**ADC Planning Consultation
Response from the Historic Buildings Adviser**

Application Number	EG/18/12/NMA
Address	Shelley House & Elm Tree Stores, Eastergate
Description	Various amendments to ground and first floor.
Case Officer	Susan Leeson
Site Visit	4 July 2012

E01 - Front Elevation - Shelley House (Units 7 & 8)

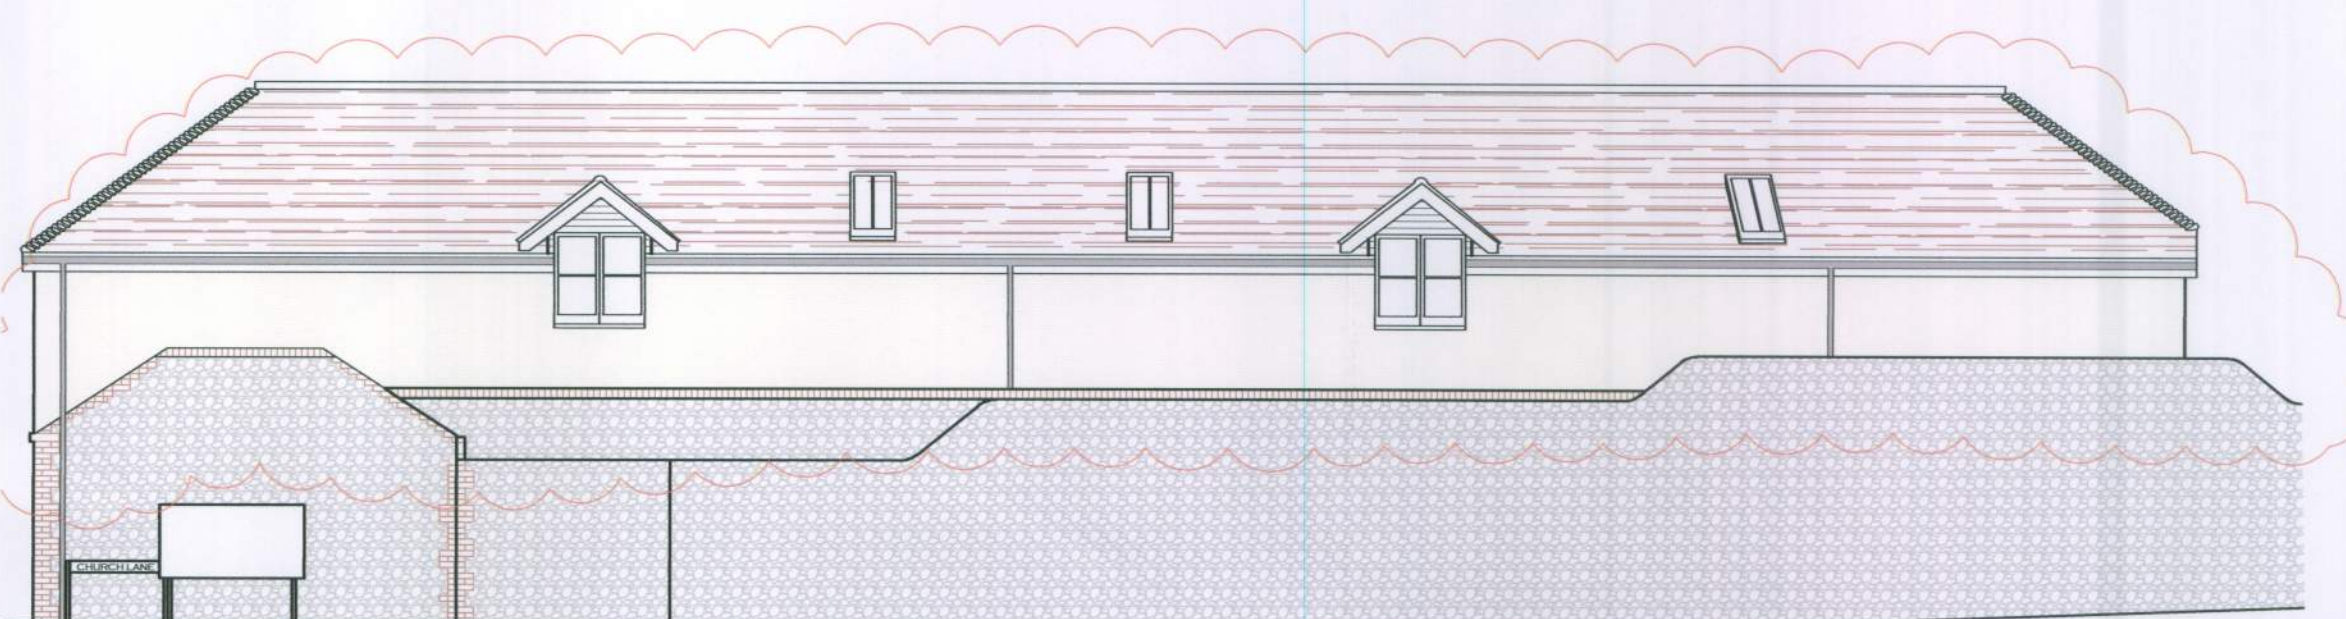
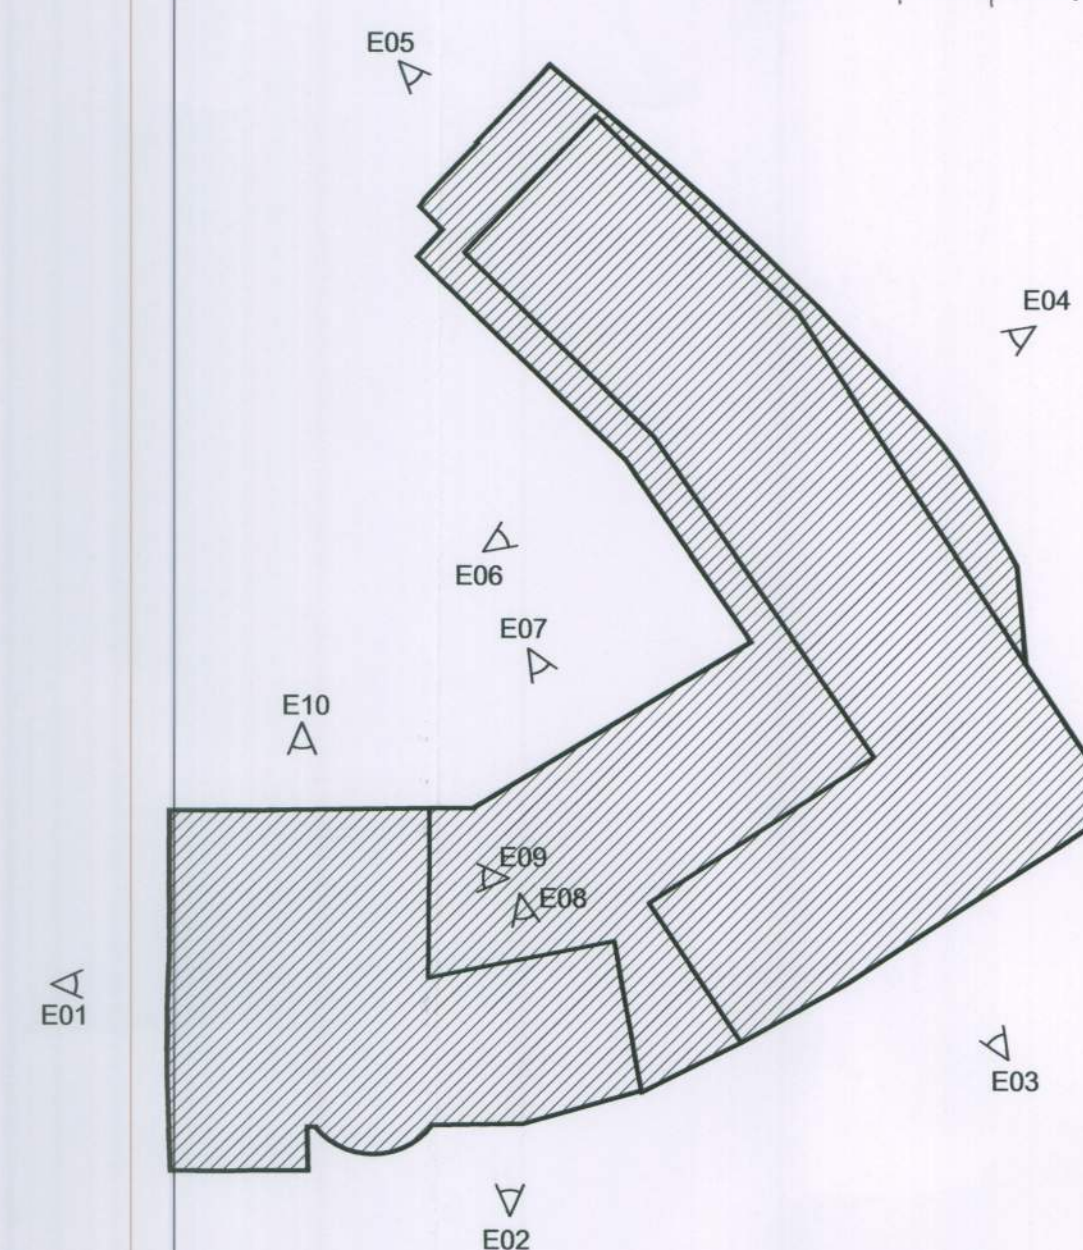
The main issue with these proposed amendments is the changing of the first floor elevations from flint to render. This is of particular concern on the front where flat render could contrast severely with the historic painted flint work below. On the Church Lane elevation there is further concern that the addition will simply appear as a new build and will not reflect any of the historic character or quality of the immediate location. This is important to other listed buildings such as Old Farm Cottage opposite, whose setting and appreciation could be affected by such a change.

A remaining issue is the use of roof lights on the front elevation. Whilst two have been permitted on the building above the stores, further windows should be avoided to maintain the listed building's character and appearance, particularly within a Conservation Area.

E04 - Church Lane Street Elevation - Elm Tree Stores (Units 1, 2, 3 & 4)

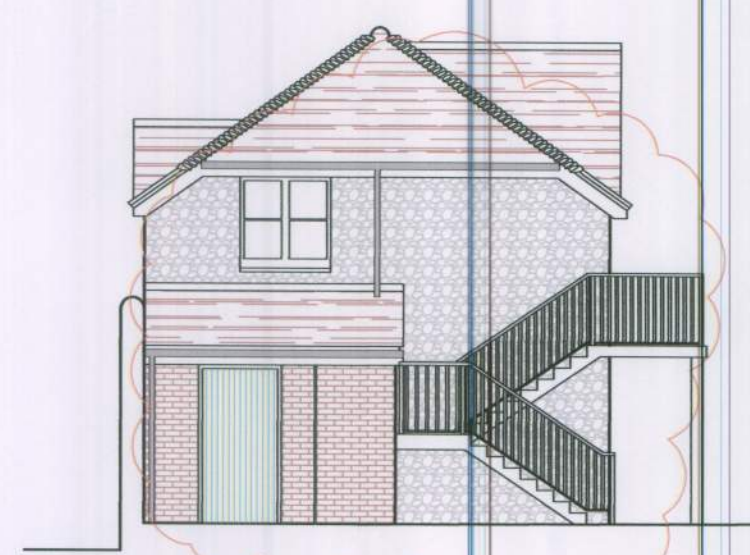
Given the height and scale of the extension and addition, there are also some reservations with the use of clay tiles, which might be seen to compete with the roofs of the main dwelling and shop. In its current form, the attached outbuilding is distinct in terms of both its height and roof treatment which is slate. This should be maintained to retain architectural clarity.
